PLANNING CONSULTATION RESPONSE

Application No	2026/0412
Proposal	Variation of conditions 2 (Approved Plans), 3 (Levels), 4 (Air Quality Mitigation), 5 (Trees), 6 (Highways Adoption Plan), 10 (Cycle Parking), 11 (Noise Mitigation), 13 (Boundary Treatment to Plots 1 7), 15 (CEMP) and 16 (Hampton Windows) of planning application 2021/1405 : Reserved matters (appearance, landscaping, layout and Scale) application for development of 91 homes, structural planting and landscaping, surface water attenuation and associated infrastructure in connection with outline planning permission 2017/1718 (Outline planning for up to 102 homes) (AMENDED PLANS)
Address	Former William Freeman Site, Wakefield Road, Mapplewell, Barnsley, S75 6ND
Date of Consultation Reply	06/08/26
Consultee	Nik King, Senior Urban Design Officer

Here are the second set of design comments on planning application 2026/0412.

Project	Originator	Functional	Spatial	Form	Discipline	Number
VWYM2	PHS	XX	XX	DR	A	07003
Boundaries Treatment Plan						
Status Code	Description					Revision Code
S2	INFORMATION					P03

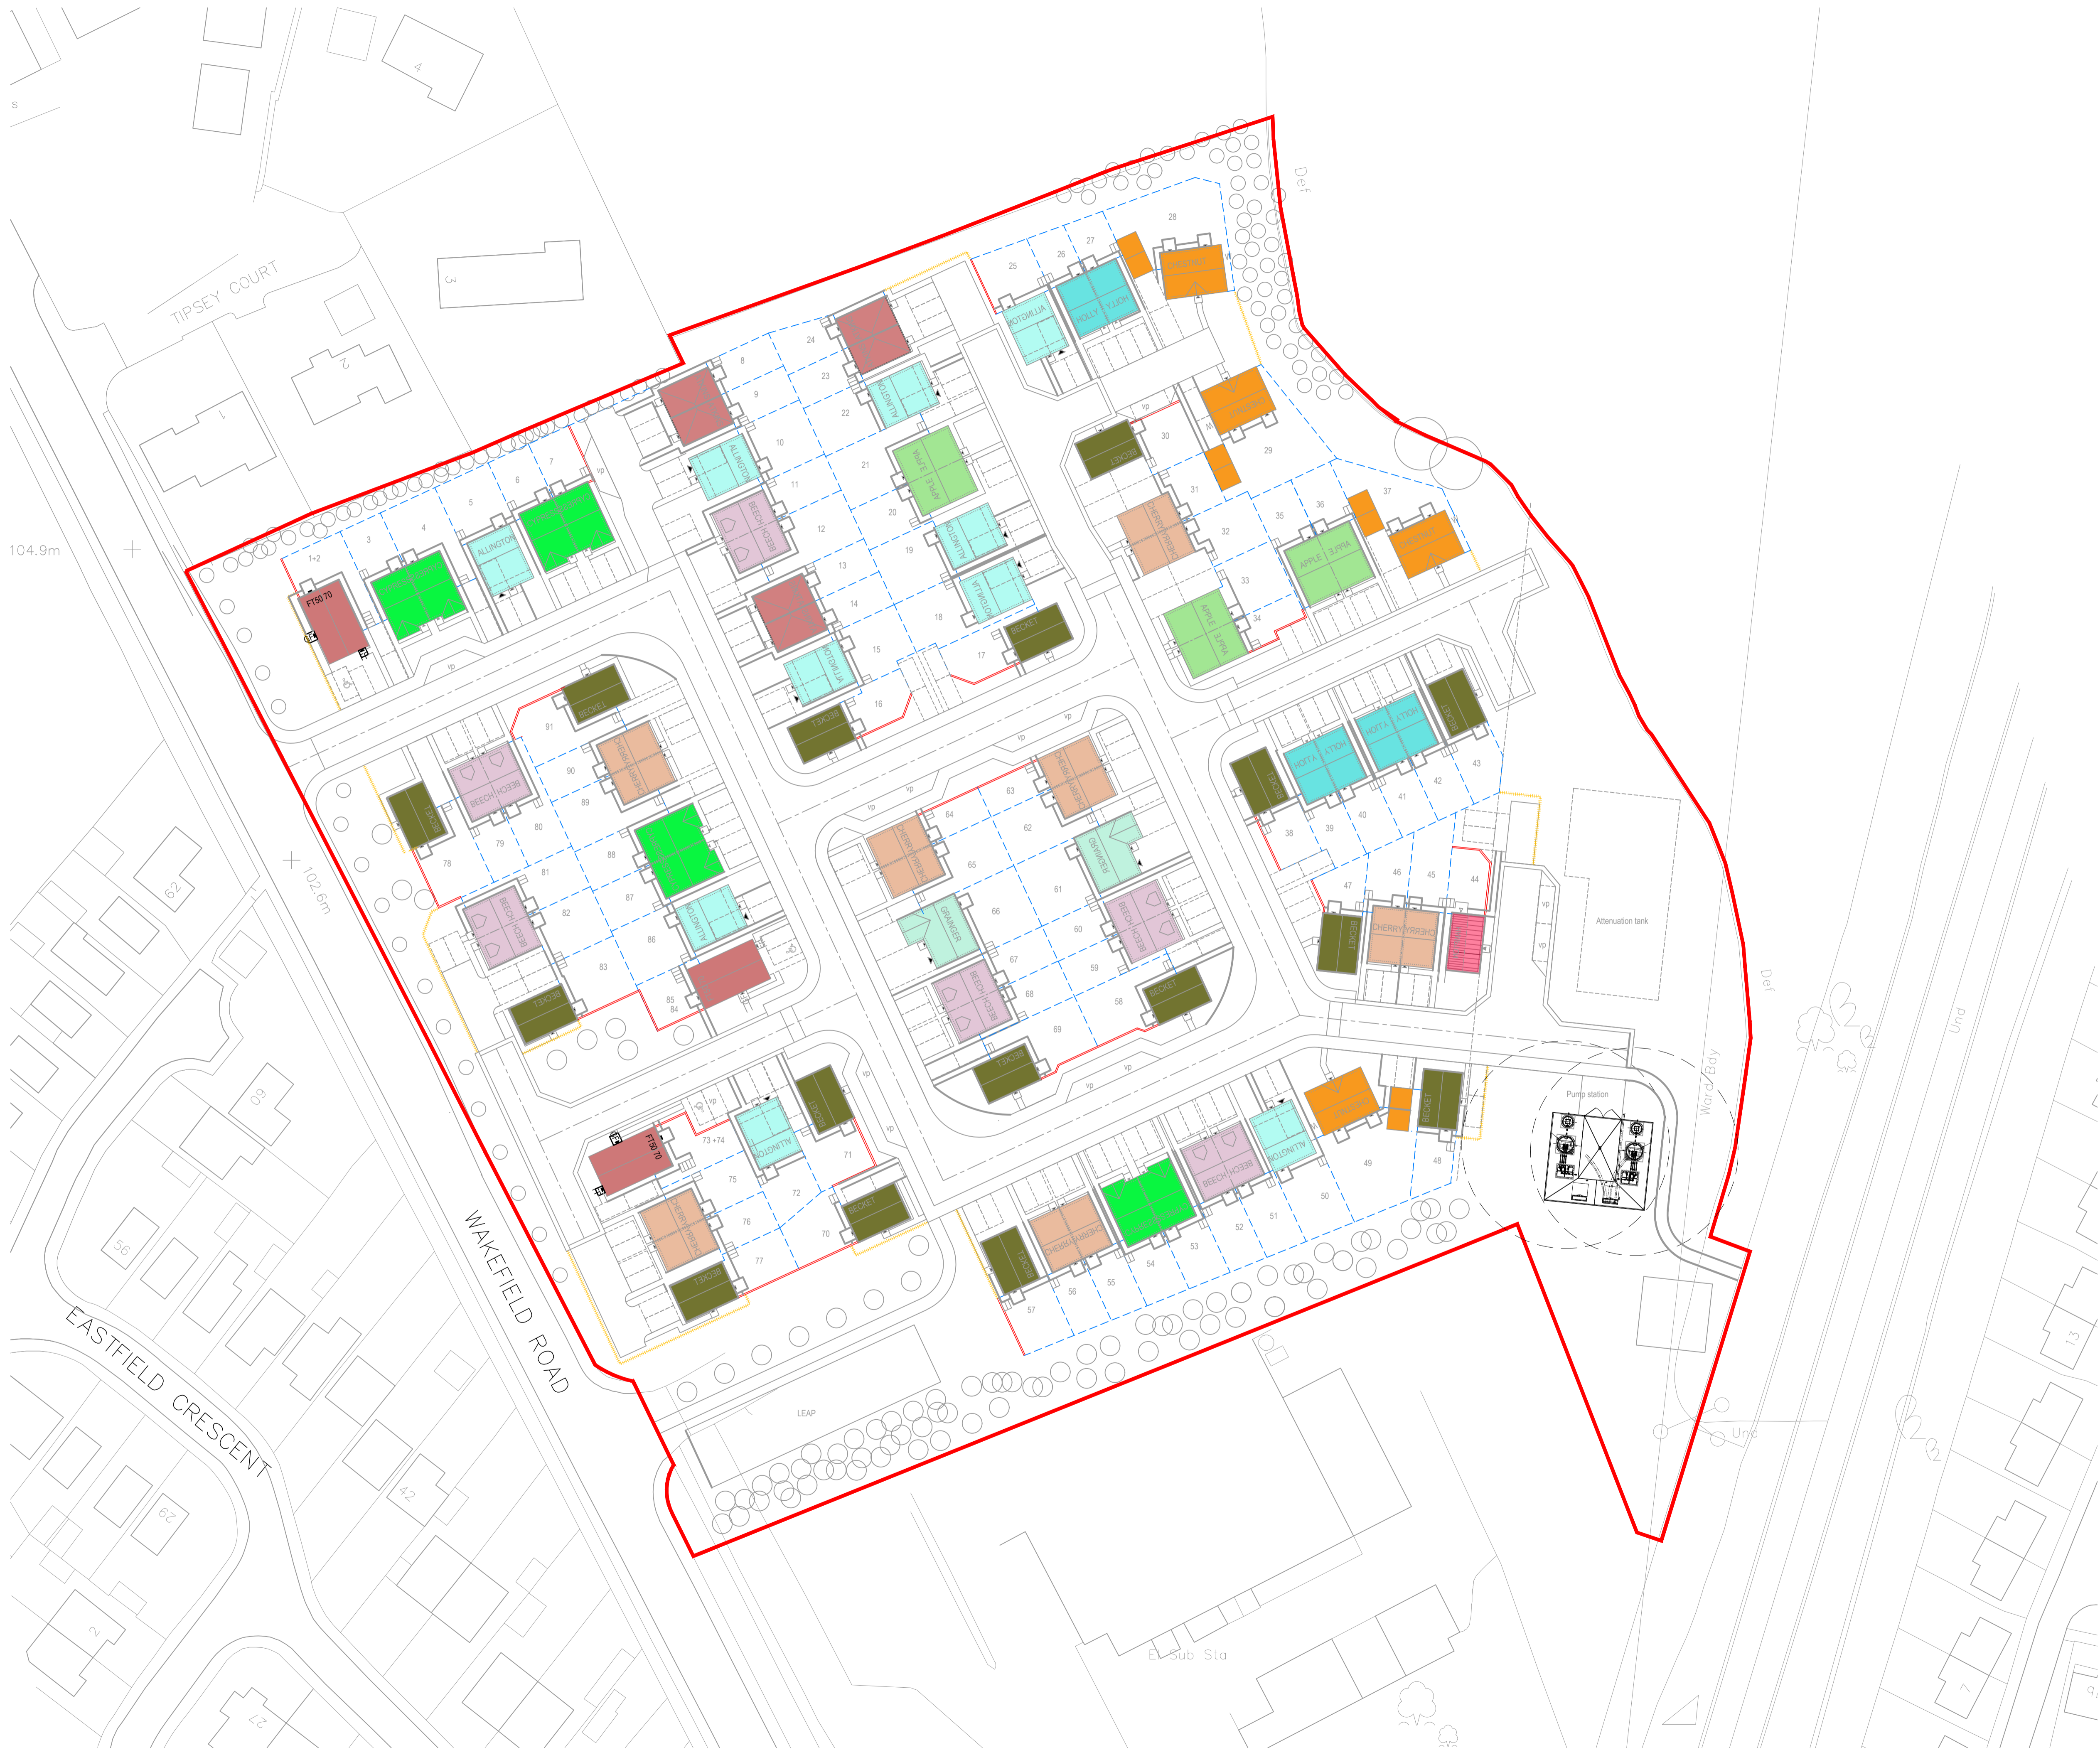
- **Boundary treatment plan-** I understand that the current 'boundaries treatment plan' will be amended to show a 900mm high metal railing around the pump station, to supplement the perimeter landscaping (the latter shown on the current 'Landscape General Arrangement Plan' rev.c). I note, however, that 'this is subject to agreement and approval with the end operator and could be subject to change'. ***Await receipt of amended boundaries treatment plan. Defer to development management as to whether to keep condition on boundary treatment of the pumping station (given potential future amendment) or remove it.***
